Our ref: HA/2021/123314/01-L01
Your ref: F/7/21/PL
Date: 05 July 2021

BUILDING A NEW 1.28 HA HIGH-TECH GLASSHOUSE, RESERVOIR AND PARKING AREA ADJACENT TO THE EXISTING 6 HA GLASSHOUSE, RESERVOIR AND NURSERY AREA

WICKS FARM FORD LANE FORD BN18 0DF

Environment Agency Position

Drawing Title
Proposed Lagoon

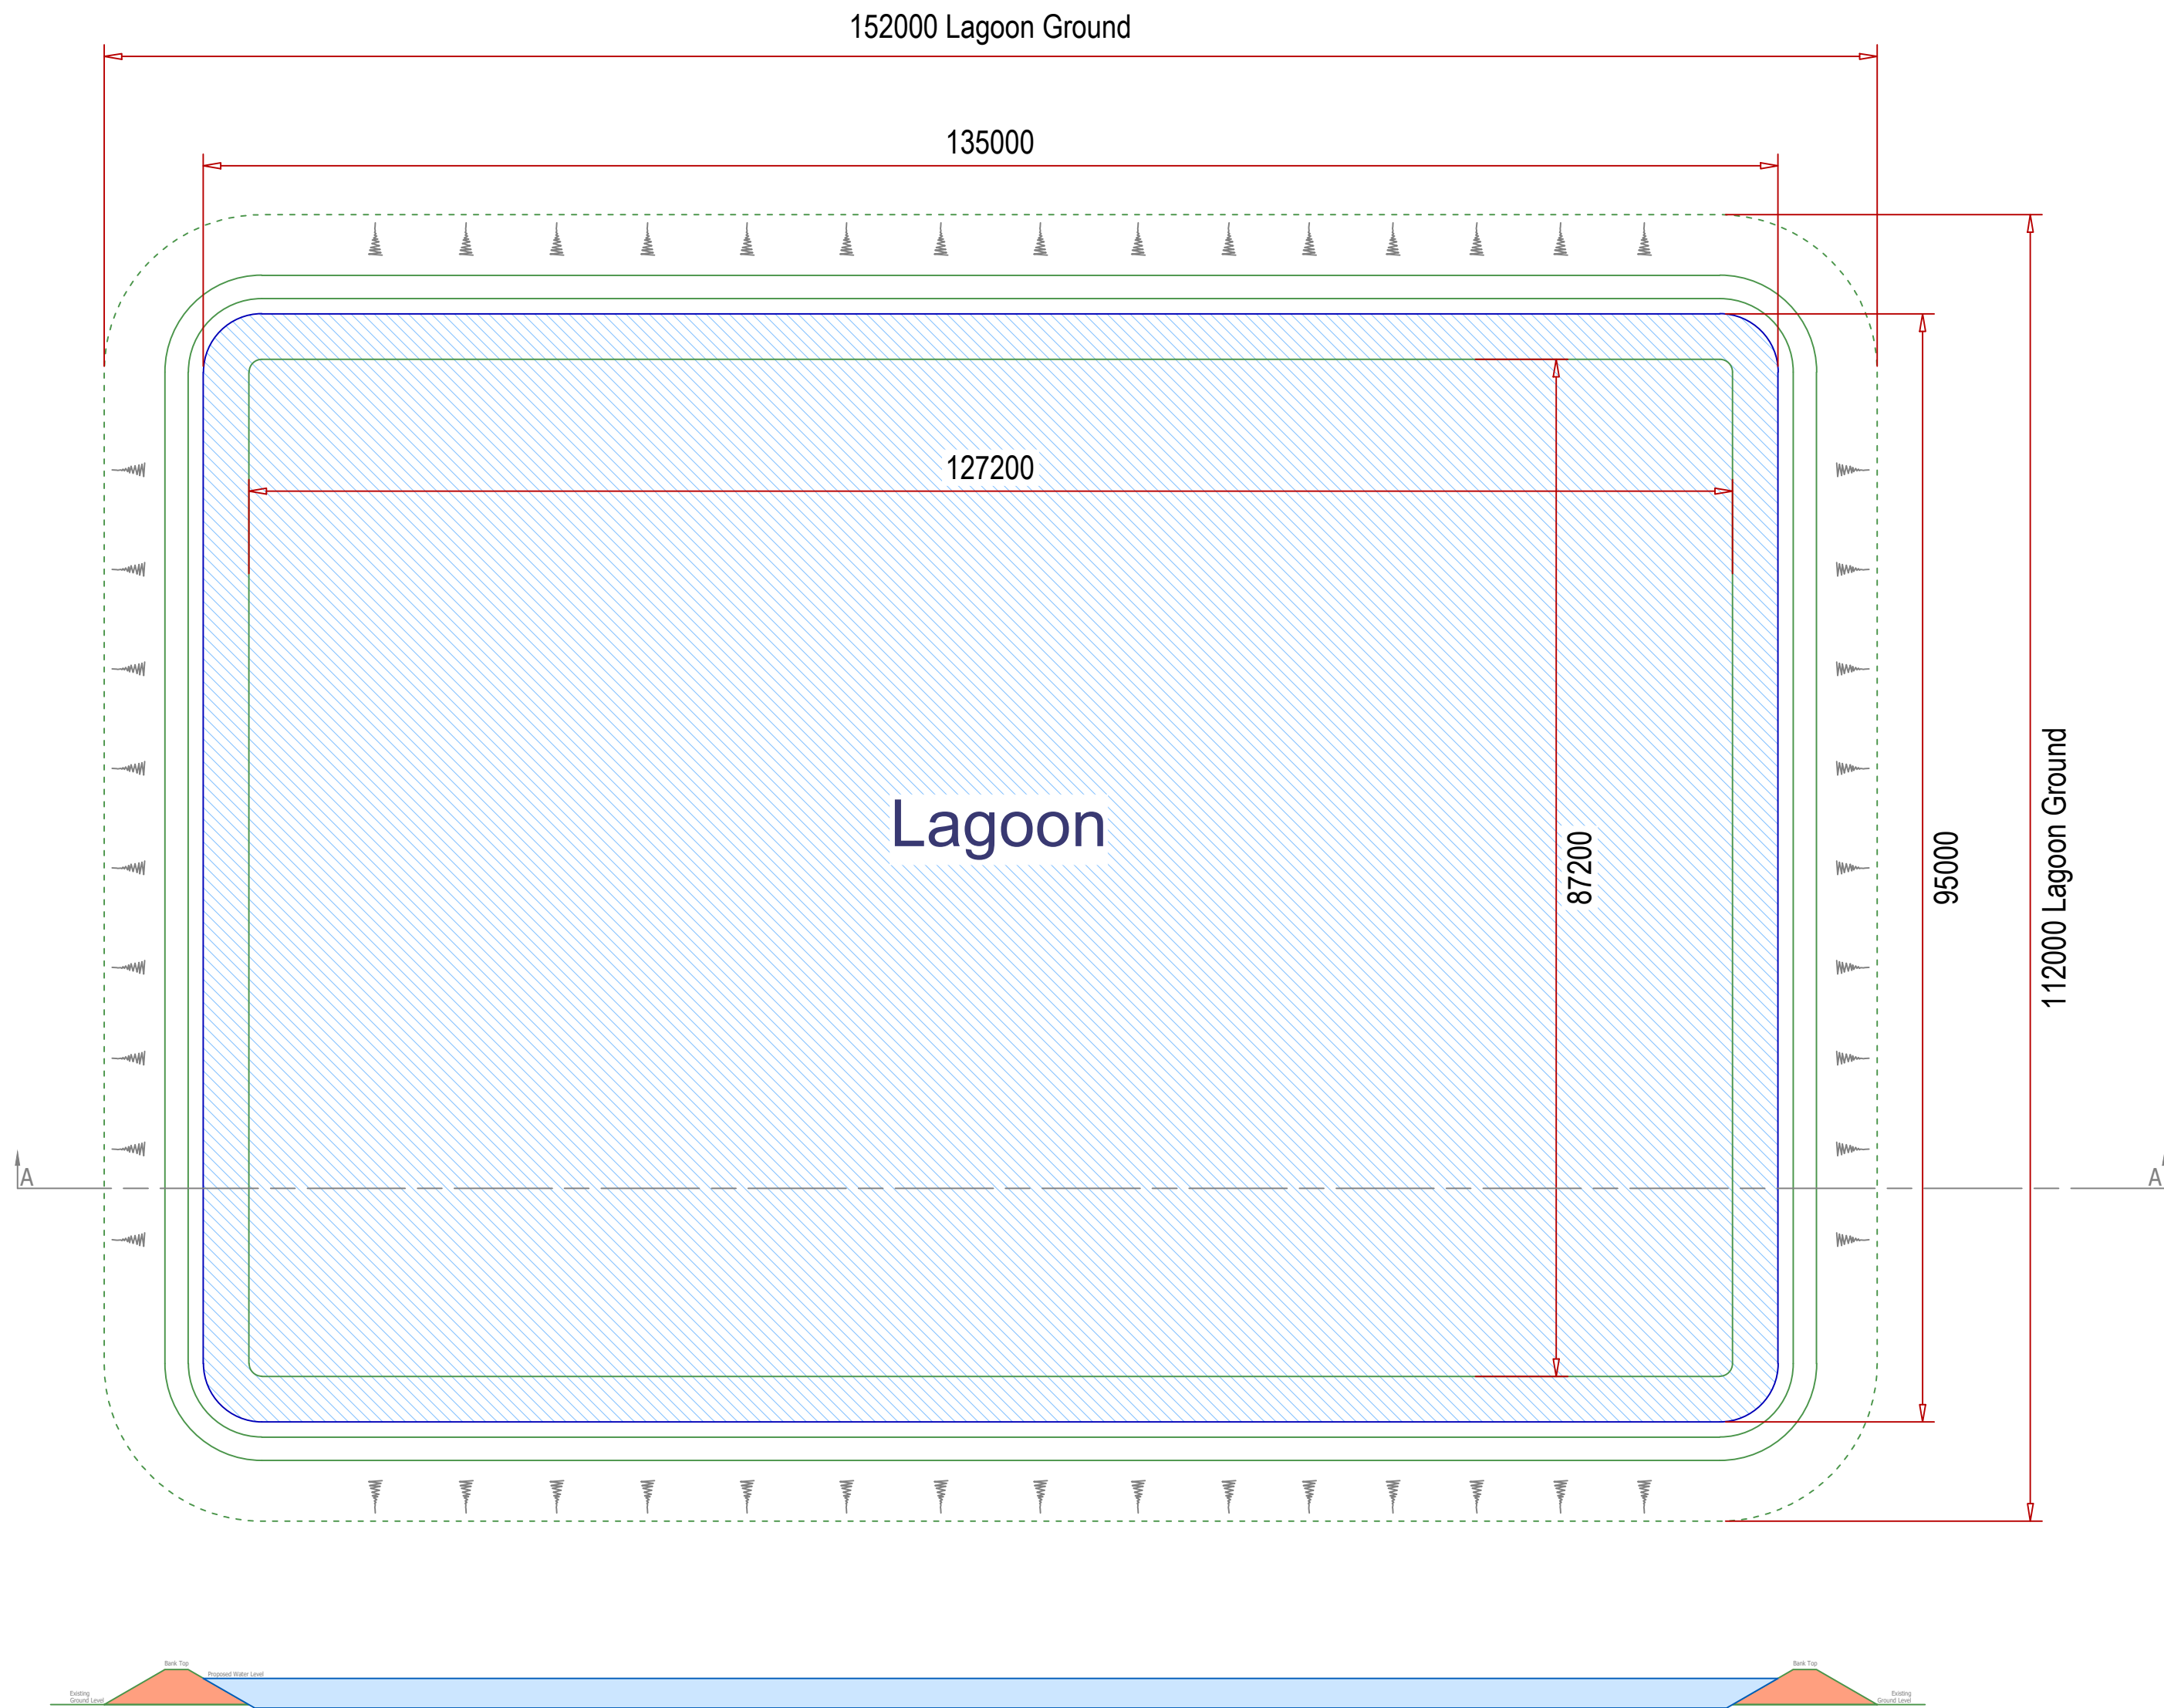
- There has been no consideration for flood plain compensation
- There is no indication of the capacity of the reservoir in the submitted Flood Risk Assessment (FRA). Our initial calculations suggest that this would be classed as a Large Raised Reservoir. Subsequently, we would require further details of how this proposal would be planned, designed and constructed in accordance with the Reservoir Act requirements. This includes appointing an All Reservoir Panel Engineer as a construction engineer to oversee and supervise building the reservoir

- A large raised Reservoir will require an understanding of what will be at risk if there is an uncontrolled discharge of water (especially with relation to the railway line and subsequent embankments), an on-site plan to manage a reservoir incident and ongoing maintenance and supervision

To overcome our objection, the applicant should submit a revised FRA which addresses the points highlighted above.

RESERVOIR SECTION
(Scale 1:100)

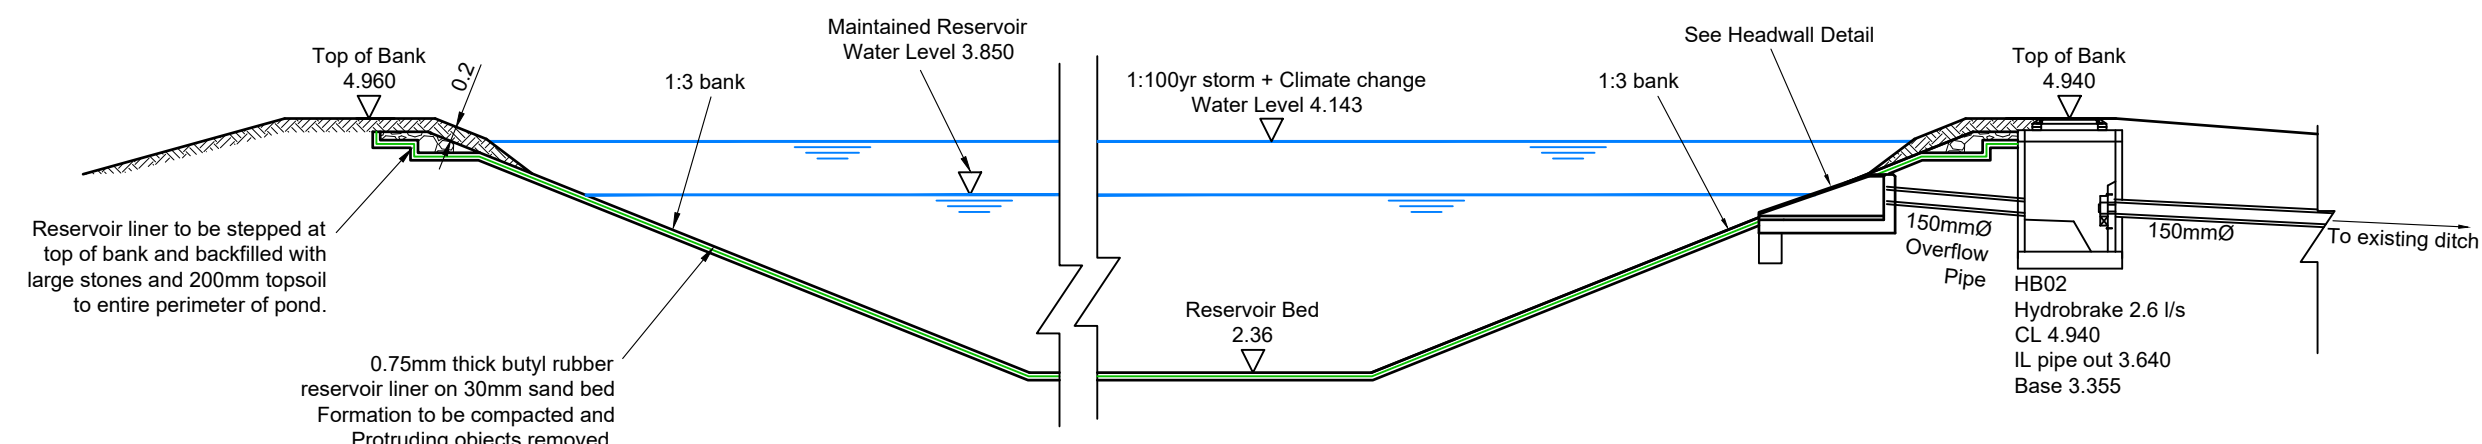
- The reservoir should be constructed in accordance with the Small embanked reservoirs CIRIA Guidance 161 (side slopes 1 in 3 and a crest width of 3 metres)

and there should also be details of the overflow arrangement
